From: Amanda Scholes on behalf of Planning.Responses
Sent: 04 July 2017 08:33
To: Planning Scanning
Subject: FW: Planning Consultation on LU/177/17/DOC

I would like to make the following comments in respect of the details submitted in connection with condition 10, 14 and 15 of planning application LU/314/16/PL:

APPLICATION LU/177/17/DOC
NO:

Description of Works: Application for approval of details reserved by condition imposed under planning permission LU/314/16/PL relating to condition No. 3 (Landscaping scheme), 4 (Habitat mitigation strategy), 6 (Foul & Surface water sewerage disposal), 10 (Details of plant & equipment), 14 (Details of kitchen extract system & type of cooking to be undertaken in the facility) & 15 (External lightings scheme)

CANOPY WEIGHT: 120 KG (APPROX)

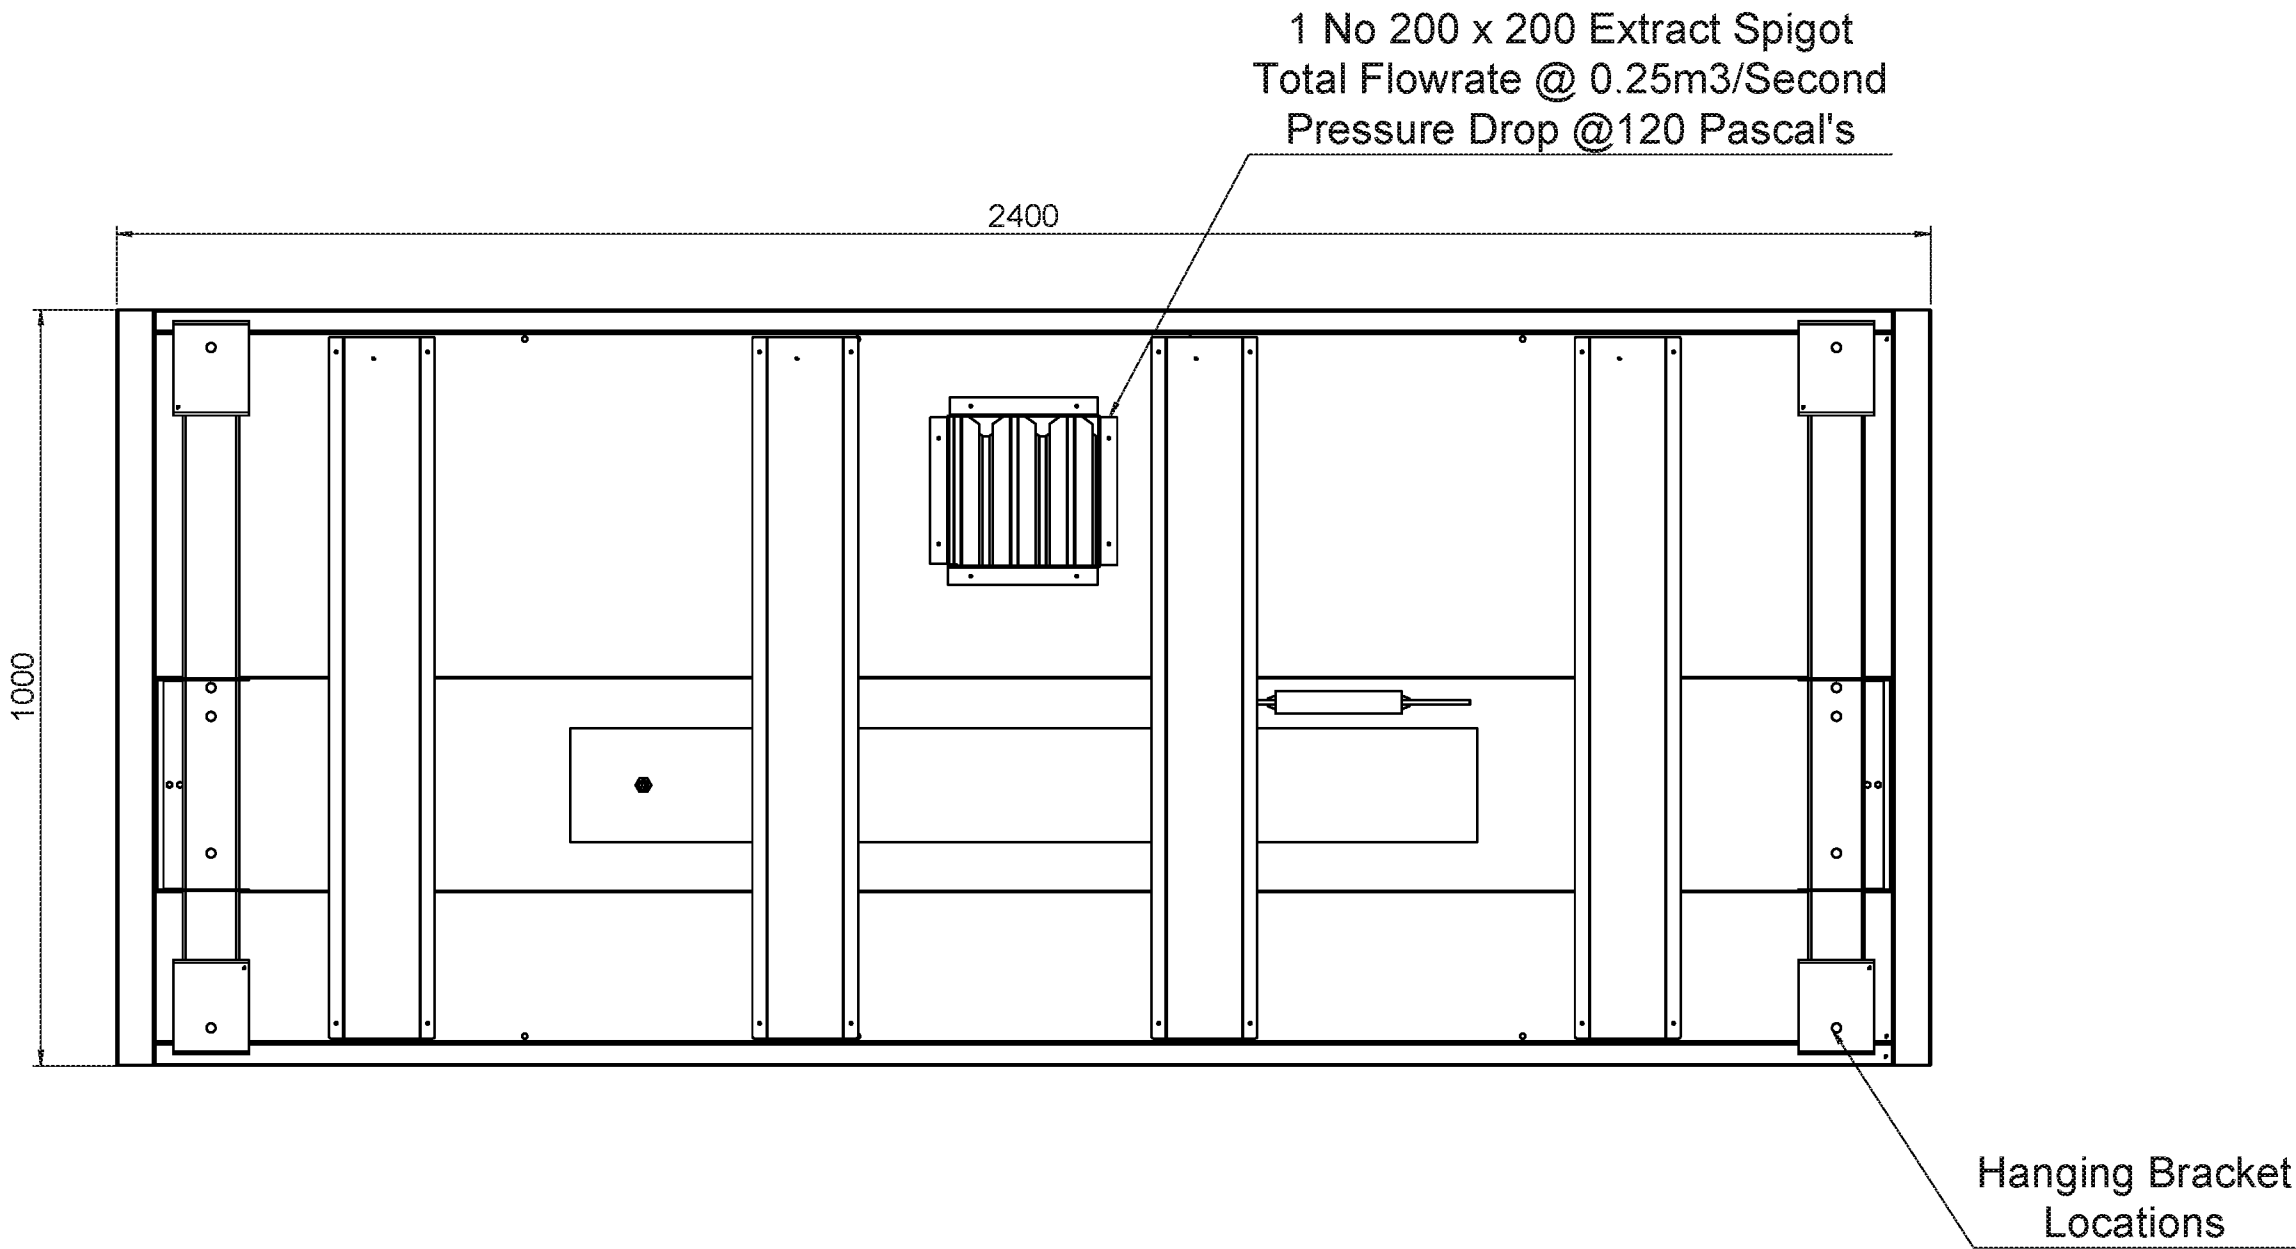
The information provided in the statement from Wilmott Dixon, dated 30 May 2017 indicates that only a very basic level of catering will be provided and as such the odour generation is likely to be minimal. As such I am satisfied with the proposals and that this condition can be discharged.
